City of Albuquerque

**DESIGN HYDROLOGY SECTION
123 Central NW, Albuquerque, NM 87102
(505) 766-7644**

REF: GRADING AND DRAINAGE PLAN FOR THOMAS ELECTRIC (J14-D45) RECEIVED JANUARY 7, 1985

DRAINAGE PLAN
80: ASPEN AVENUE, NW
LOT 1A (SEPARATE LOT) IS PENDING
PREVIOUS ADDITION
ALBUQUERQUE, NEW MEX CO

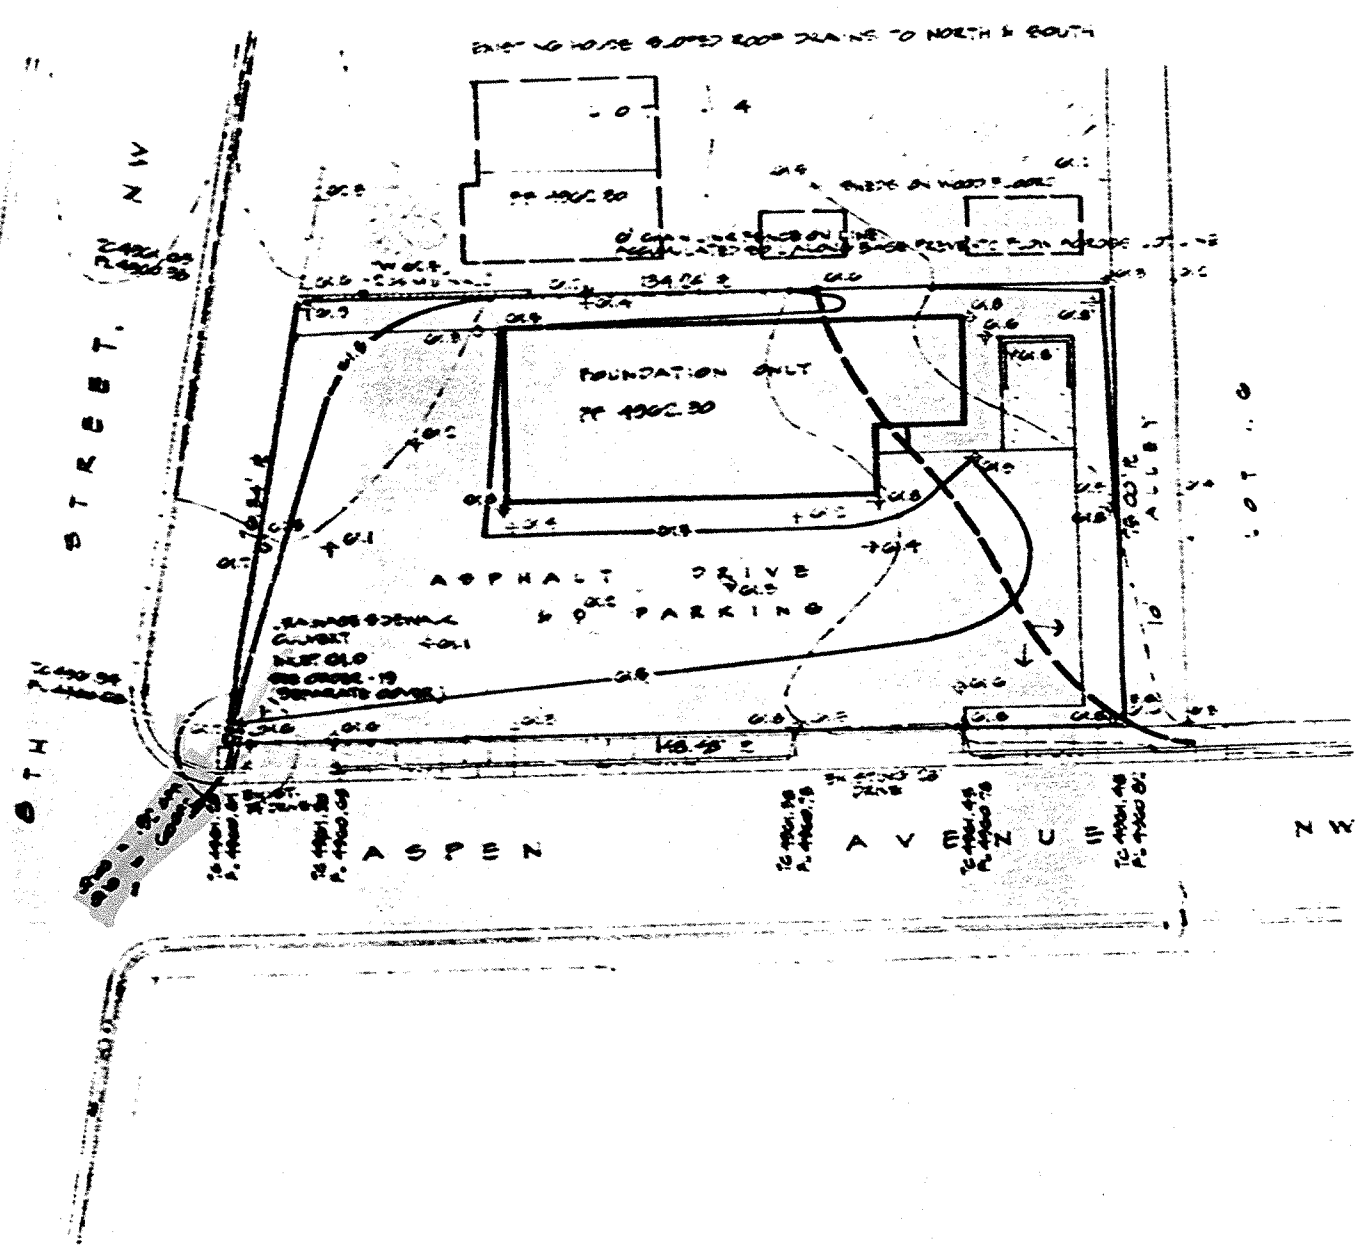
1. Based on the submittal, you are only seeking foundation approval. Generally, this approval is given while the building permit plan is in the process of review. With a foundation approval, the owner accepts all responsibilities and risks should the plan change. Therefore, if you are seeking a foundation permit I strongly recommend that a final grading plan be submitted for review prior to granting foundation approval.
2. The line shown on the plan as the division of flows is incorrect unless changes in the proposed grading are planned. The slope of the property is from the NE corner to the SW corner crossing this line.
3. City approved alley grades are required if the site is abutting an unimproved dedicated City alley.
4. Downstream capacity has not been addressed to justify free discharge.
